Ref 2020/92309.

As arranged yesterday I enclose a copy of my 2017 letter concerning the 2017/92271 proposed development at 151 Heckmondwike Rd Dewsbury.

I received notice of the proposed development ref 2017 92271 at 151 Heckmondwike Road Dewsbury Moor, this is next door to my bungalow 143 Heckmondwike Road.

Project: Proposed residential development of 6 dwellings at Heckmondwike Road
Client: LGS Construction, 4A Tateley Lane, Gawthorpe, Ossett WF5 9RG
Dwg Title: (20806)1_Site Plan
Scale: 1:100 @ A1
Date: May 20

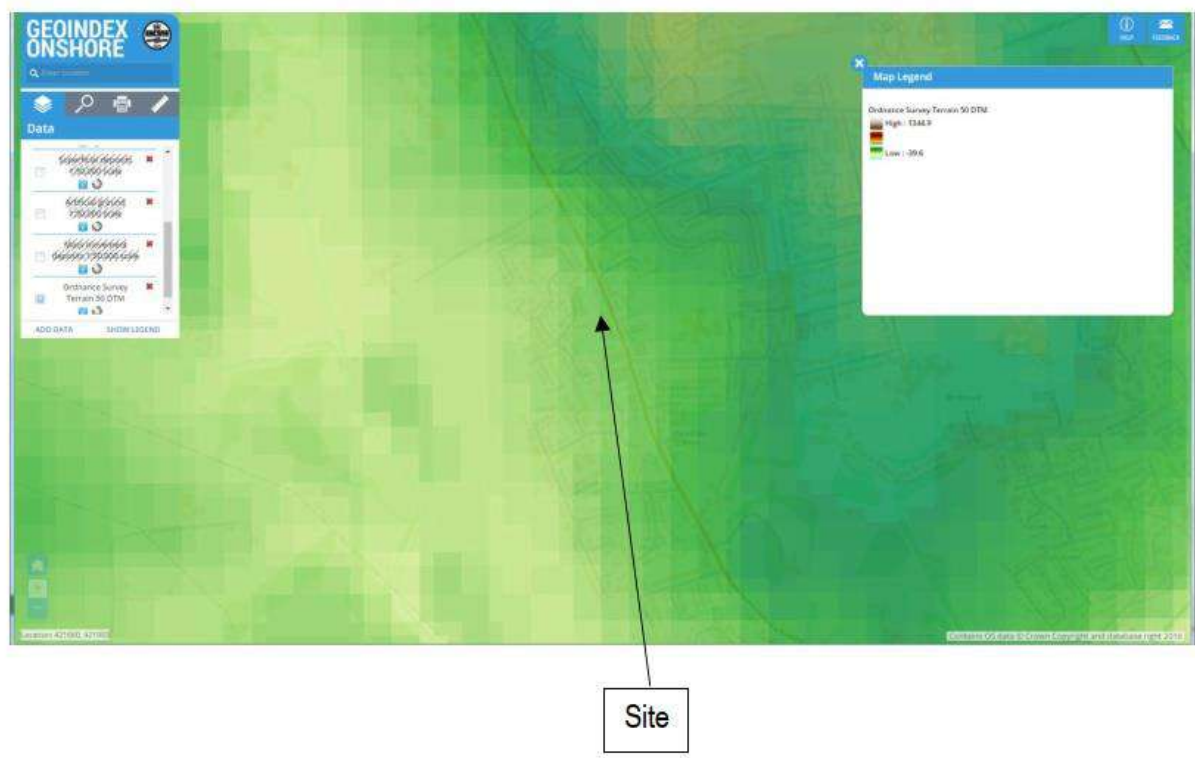
The first point is that the parking spaces of vehicles on the original garden of No 151 is approximately 8-9 feet below my patio.

There was a stone-brick wall dating from the original cottages on the site. This wall partially collapsed in 2008 into the garden below and we intend to renovate it.

Plan the wall could be damaged accidentally by careless drivers. Could the vehicle parking be moved to face the fence?

Another criticism is that the plan does not show the position of my garage which is on the end of my drive, on top of the wall in question.

I am also concerned with the proposed side windows overlooking our property.
